Your Ref: OWQC1634
Our Ref: BR/262/13/L
Please ask for:
Mr P Cleveland

18th December 2013

Application for Listed Building Consent for conversion of existing listed building currently vacant to provide 4no flats. Demolition of single storey building at rear and construction of single storey extension and separate 2 storey building to provide 5no flats (9 in total)
Manor House 12 Chichester Road Bognor Regis

DRAWING TITLE
PROPOSED ELEVATIONS
SHEET 1

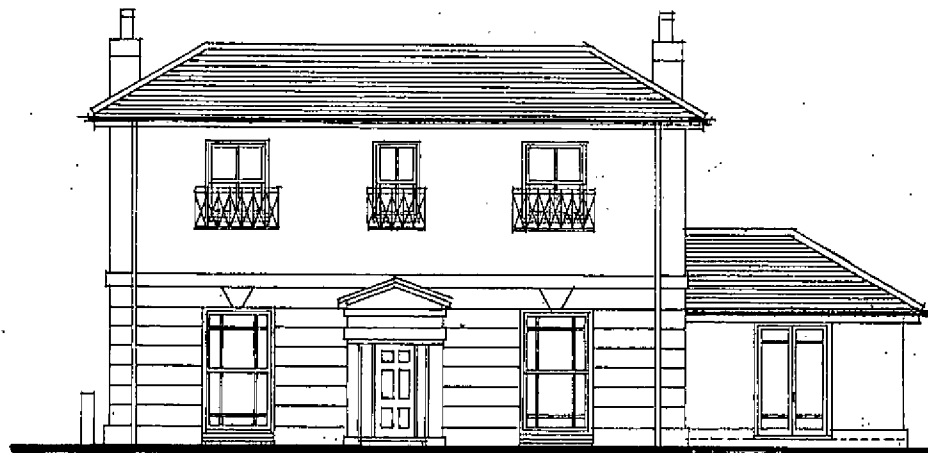
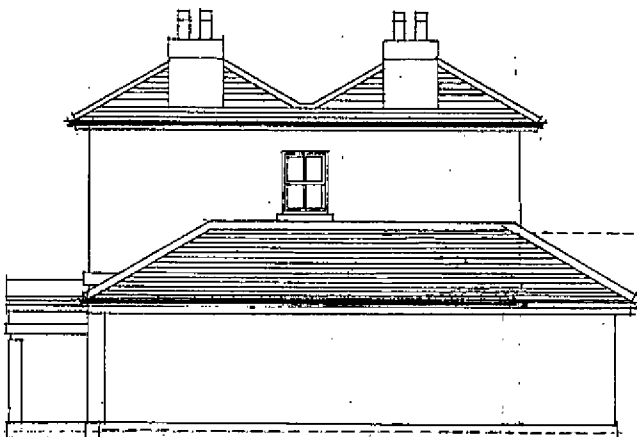
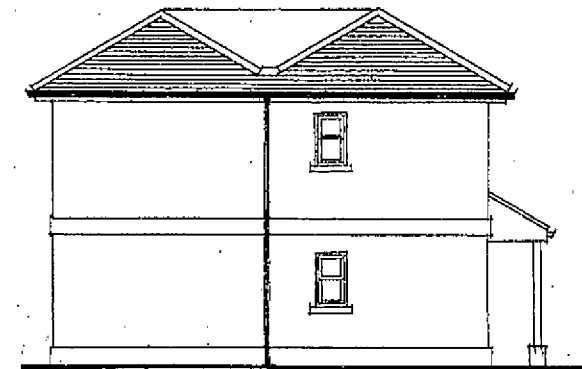
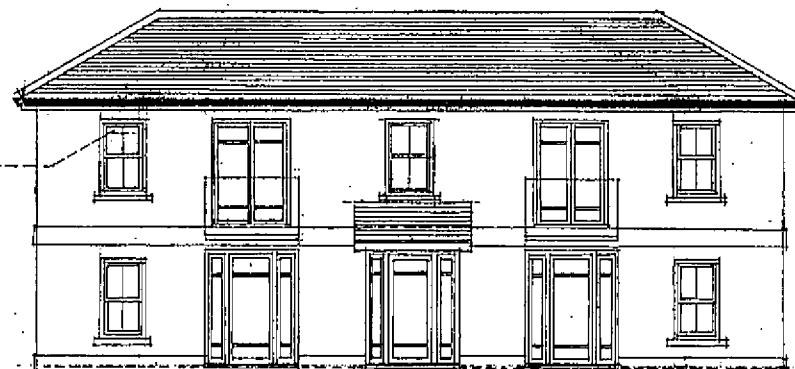
NO OBJECTION. But Members are keen for the new extension proposed to continue the characteristic features of the existing building.
